**ANGEL PLACE
LEVEL 8, 123 PITT STREET
SYDNEY NSW 2000**

RESPONSE TO COUNCIL COMMENTS: HERITAGE LETTER

This letter has been prepared to respond to comments provided by Strathfield Council's Specialist Heritage Planner Elizabeth Black regarding the proposed conditions of consent for the proposal for Meriden School known as SSD-9692. Our comments are outlined as follows:

MERIDEN CENTRE FOR MUSIC AND DRAMA
Preliminary Finishes Selections - Indicative only

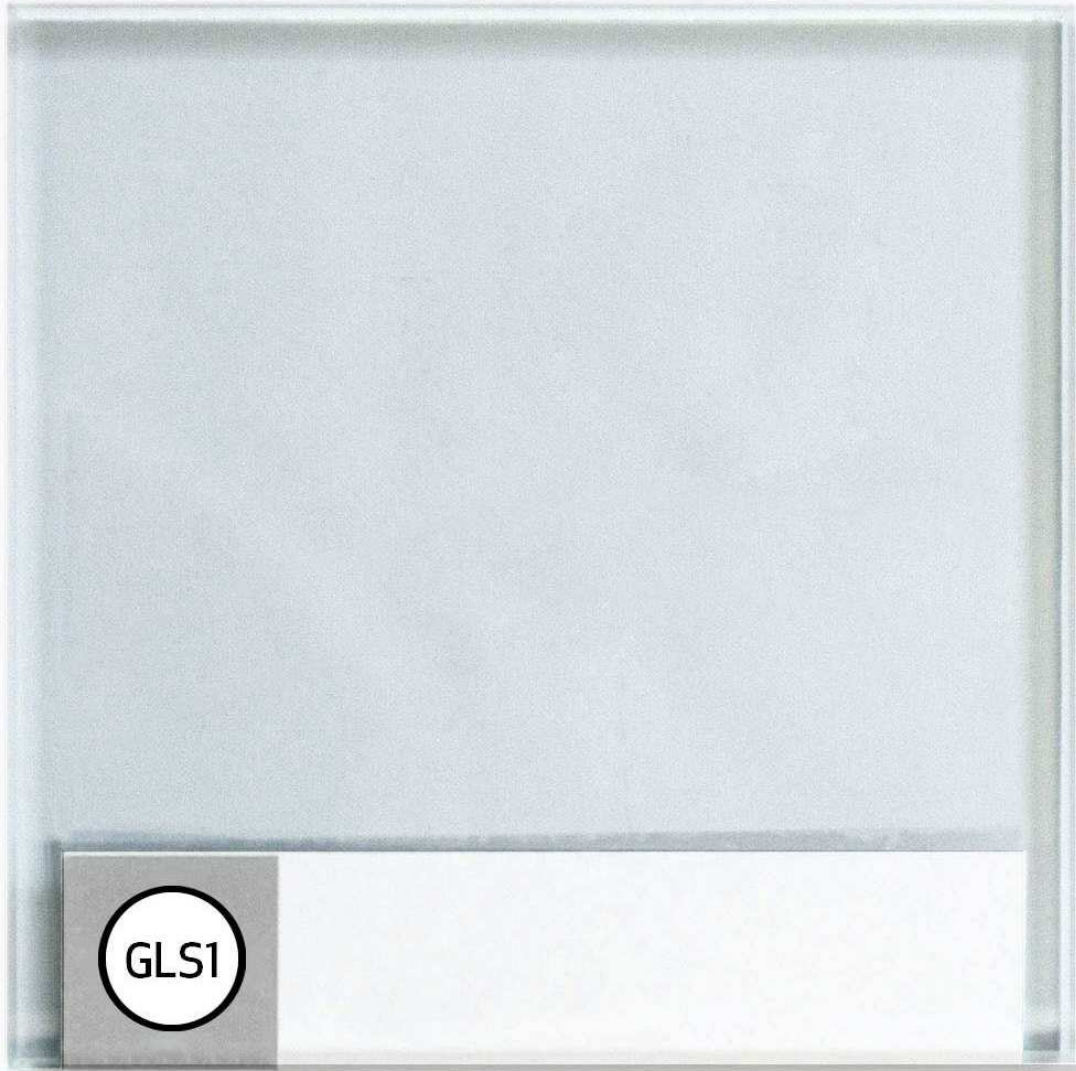
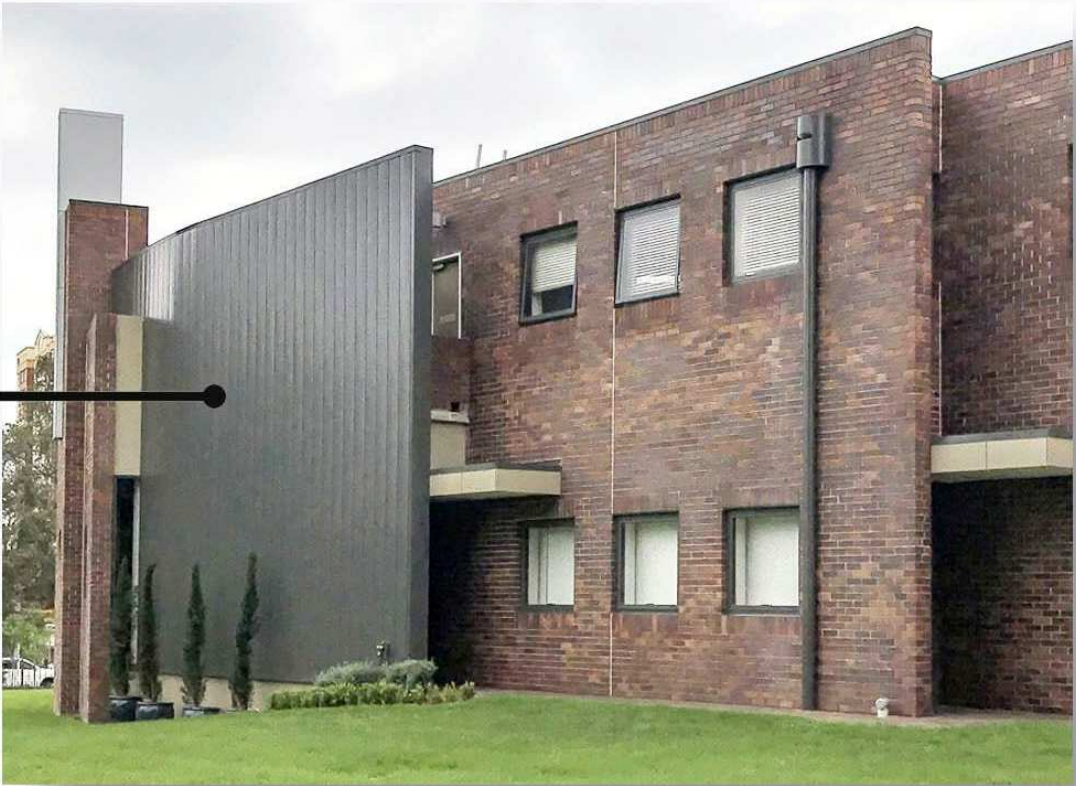
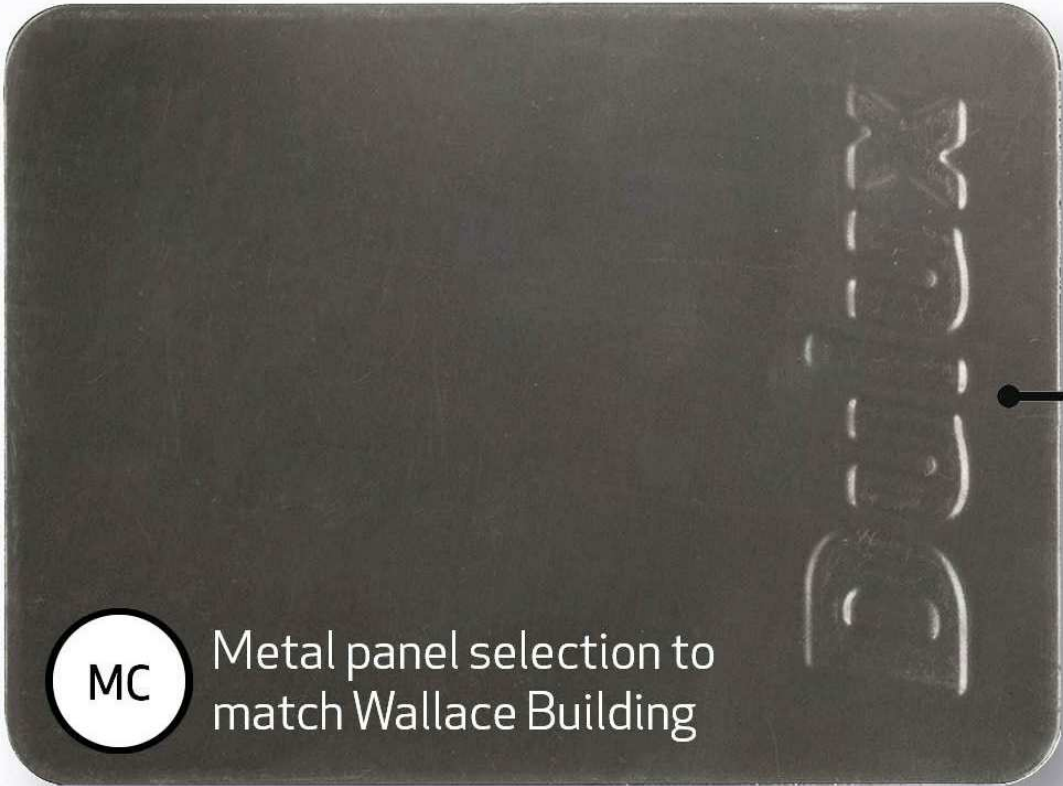
Strathfield Council Comment	Urbis Response
<p>"A schedule of materials is to be submitted to and approved by Strathfield Council's Heritage Advisor prior to the issue of the Construction Certificate. The brickwork on the Centre for Music and Drama is to incorporate a multi coloured brick wall facing the street that reflects the brickwork of the neighboring building (Hope House)."</p> <p>Reason: To complement and reflect the neighboring local heritage listed building – Hope House, which dominant design feature is its patterned brick walls.</p>	<p>On behalf of Meriden School, Urbis <u>strongly objects</u> to the portion of this proposed condition which requires the design for the Centre for Music and Drama <i>to incorporate a multi coloured brick wall facing the street that reflects the brickwork of the neighbouring building (Hope House)</i>.</p> <p>A materials schedule has been prepared for the Centre for Music and Drama design and is included in this consolidated response. The materials schedule demonstrates that the design for the Centre for Music and Drama has adopted a masonry face towards Margaret Street, including a range of brick tones complementing the immediate built form and streetscape character of the heritage item and the individual elements therein. This approach is appropriate as it responds to the dominant brickwork character of the streetscape whilst also allowing for the use of contemporary brickwork design.</p> <p>The adoption of multi-coloured brickwork pattern that reflects or replicates the adjoining Hope House building is not an appropriate heritage response to the place. The replication or reproduction of period detailing including adopting the same brickwork pattern, is against best heritage practice and would have a detrimental impact on the significance of the</p>

Strathfield Council Comment	Urbis Response
	<p>heritage item and the streetscape character of the place. It would result in a confusing heritage outcome and diminish the value of the historic Hope House brickwork.</p> <p>Adoption of contemporary brickwork in neutral and complementary tones as proposed, provides for an appropriate heritage response to the place which also embraces the contemporary nature and design of the new building.</p> <p>We request that this proposed condition of consent is removed/not adopted in the final approval.</p>
<p>"Prior to a Construction Certificate being issued, an archival photographic recording of the buildings fronting Margaret Street and 4 Vernon Street is to be prepared to Council's satisfaction. The recording is to be in digital form, prepared in accordance with the NSW Heritage Division of the Department of Environment and Heritage guidelines titled "Photographic Recording of Heritage Items using Film or Digital Capture". One copy of the record is to be submitted to Council to be lodged with Council's Archives (see http://www.environment.nsw.gov.au/Heritage/publications).The photographs must be sufficient to document the external context and appearance of the building and/or structure, and should be confirmed with Council's Heritage Advisor."</p> <p>Reason: Where demolition is allowed, a photographic record of the building must be prepared for the site and submitted to Council prior to the commencement of the demolition works."</p>	<p>This is a typical condition of consent where the proposal seeks approval for the demolition of a heritage item or demolition of a building in a conservation area. This proposed condition is acceptable and we do not object.</p>
